RE: **Monterey Place Apts**
2306-2320 Central SW
Conceptual Grading and Drainage Plan Stamp Date: 5/16/19
Hydrology File: J12D030

Based on the submittal received on 5/20/19 the above-referenced Grading and Drainage Plan is approved for Site Plan for Building Permit and Final Plat. On the Plat, provide a Public Drainage Easement (Blanket-exclusive of buildings), to allow the alley to drain into/through your site. Be sure to name maintenance responsibility and beneficiary.

C-101

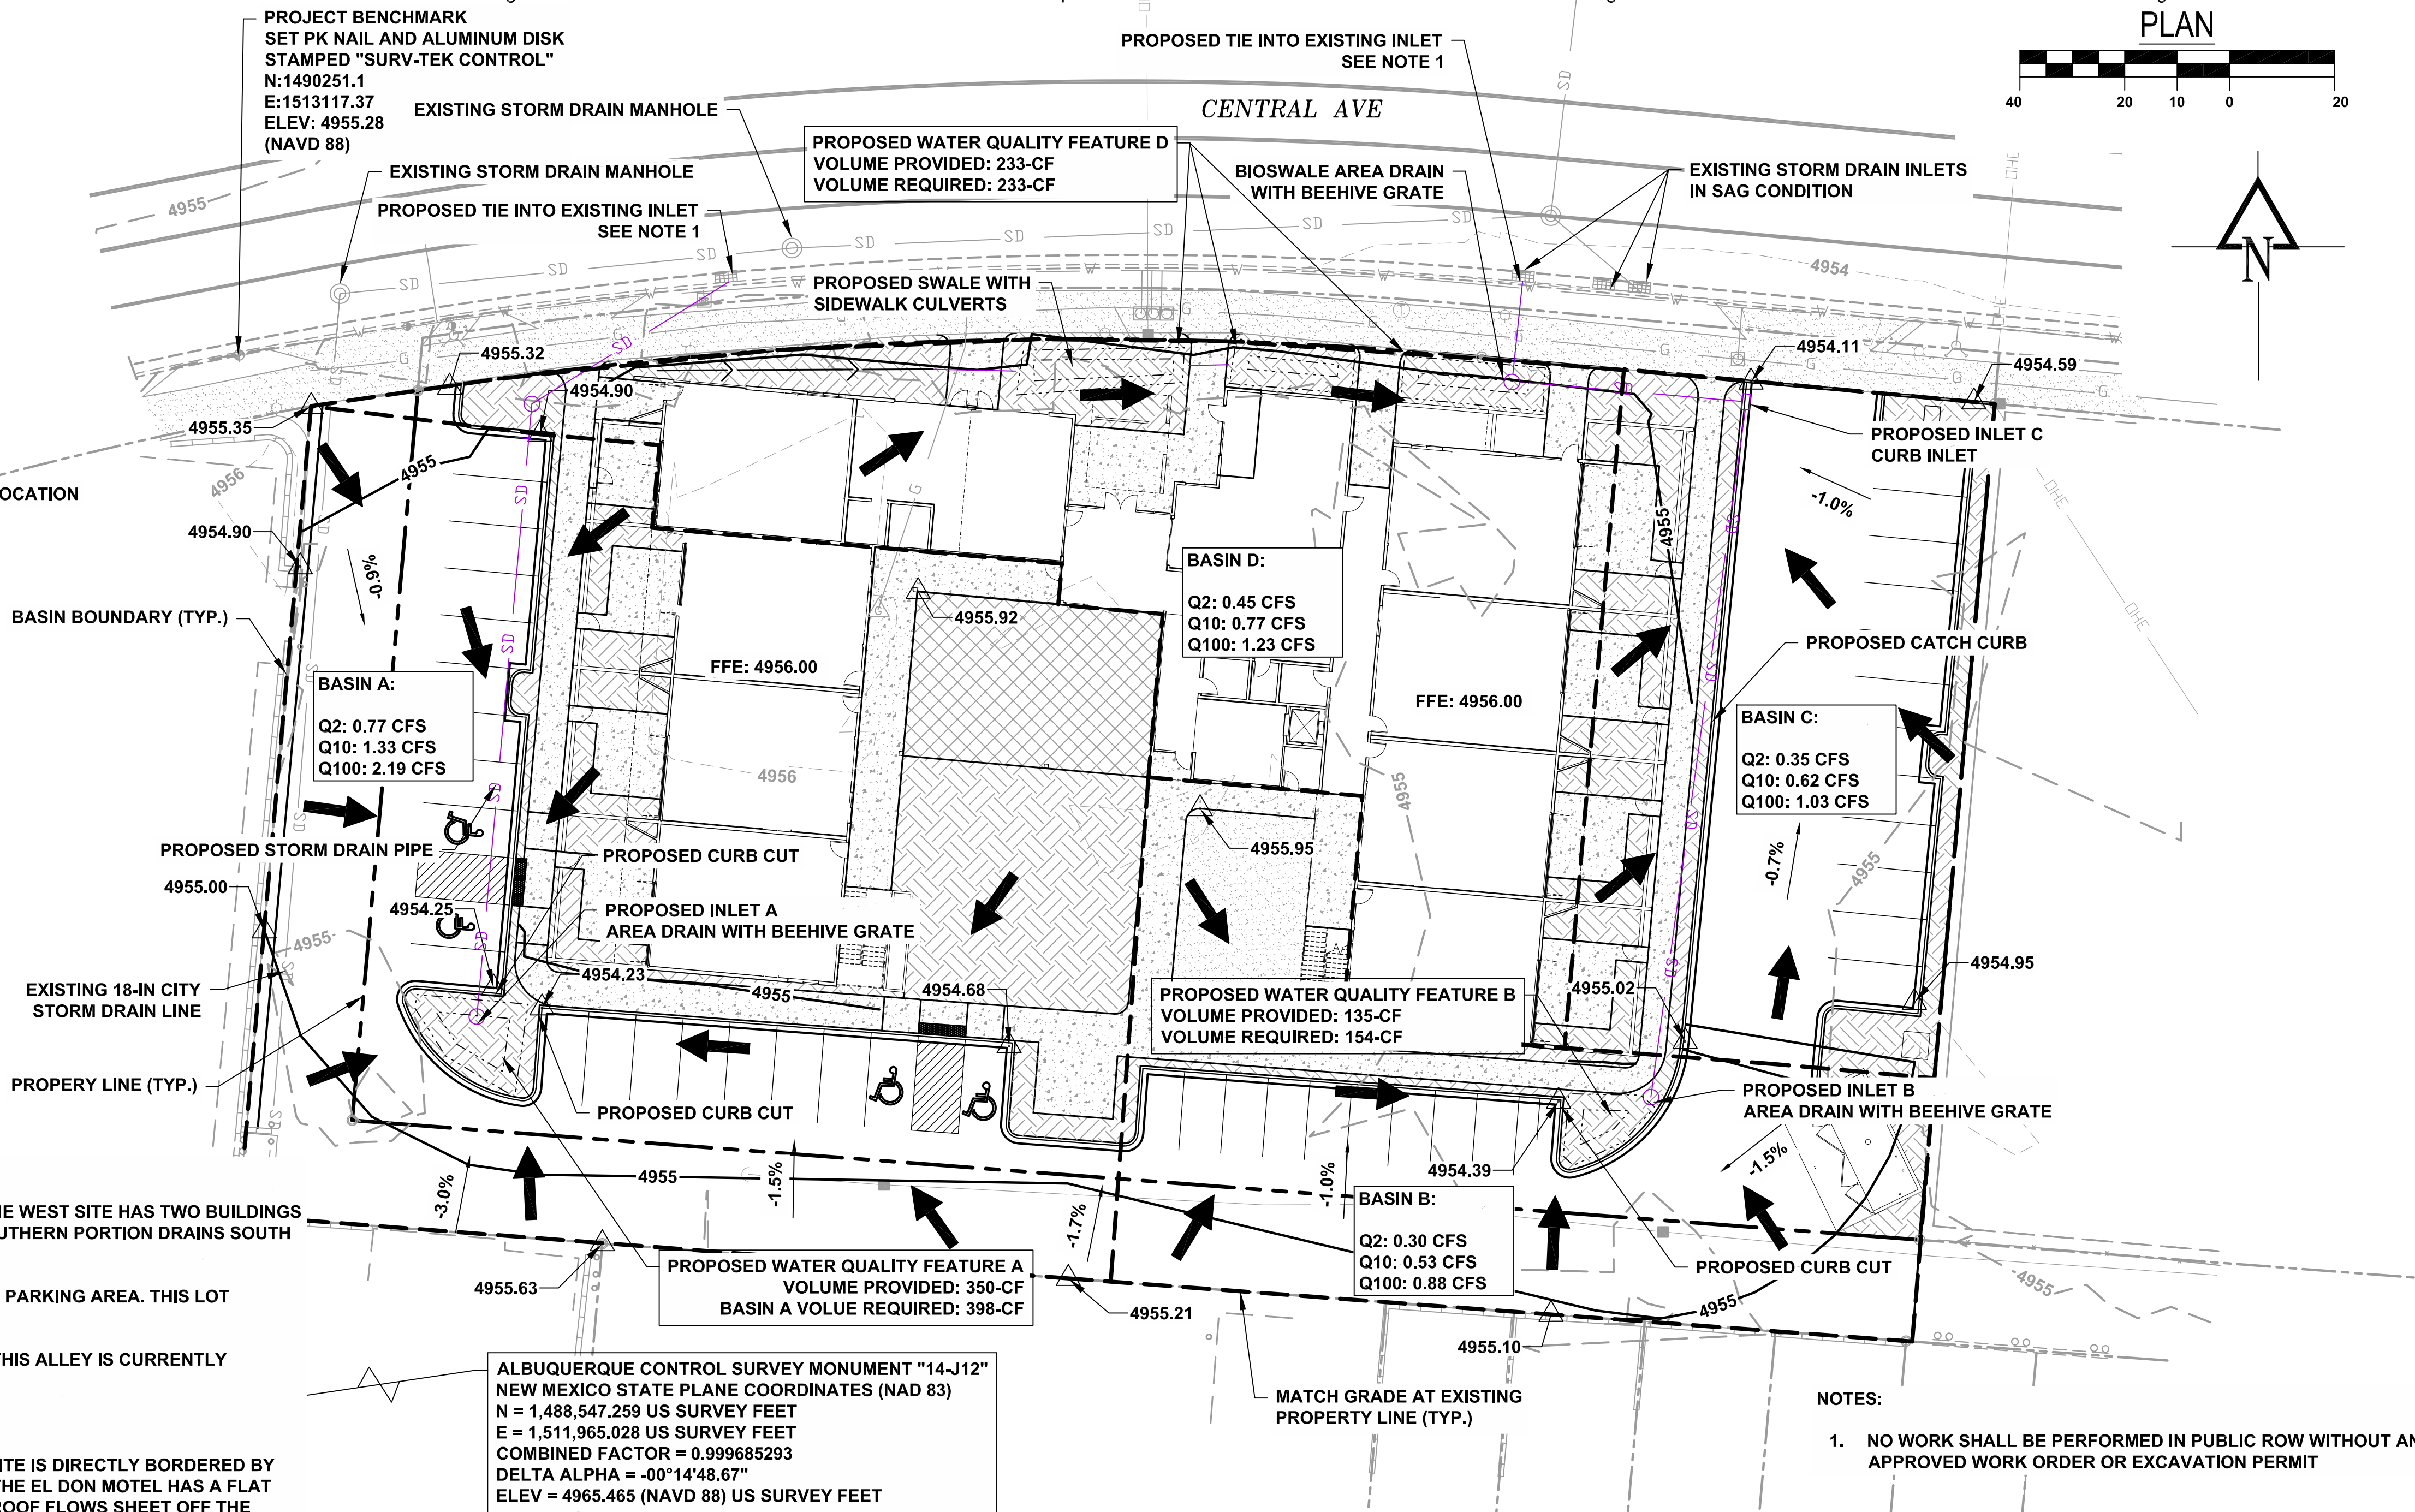
1. Remove all "Conceptual/Not for Construction" markings.
2. Provide sections through the SWQ ponds and show the SWQV and water surface elevation (WSE). Also show the 100-yr WSE.

3. Provide hydraulic calculations for the new private storm drain calculated along the Energy Grade Line.
4. Provide hydraulic calculations for the beehive grates and curb cuts; the grates need to demonstrate 2x capacity (or 50% clogging) for the 100-yr storm.

5. Provide proposed spot elevations and contours in suitable density to discern all flow patterns across the project. The flow arrows/slopes are fine for the conceptual plan, but need to be replaced with elevations in the "For Construction" plan.

6. This project requires an ESC Plan, submitted to the Stormwater Quality Engineer (Curtis Cherne PE, ccherne@cabq.gov or 924-3420).
7. Payment of the Fee in Lieu (Amount = $86CF \times \$8/CF = \688 , per sheet C-101) of onsite management of the SWQV must be made. Include a copy of the paid receipt when resubmitting.

8. Correct the error in table 4, Basin D, Fee-in-Lieu Area (906sf, not 0).
9. Additional comments may be provided at Building Permit, based on the outcome of the above remarks and level of detail shown on plans.
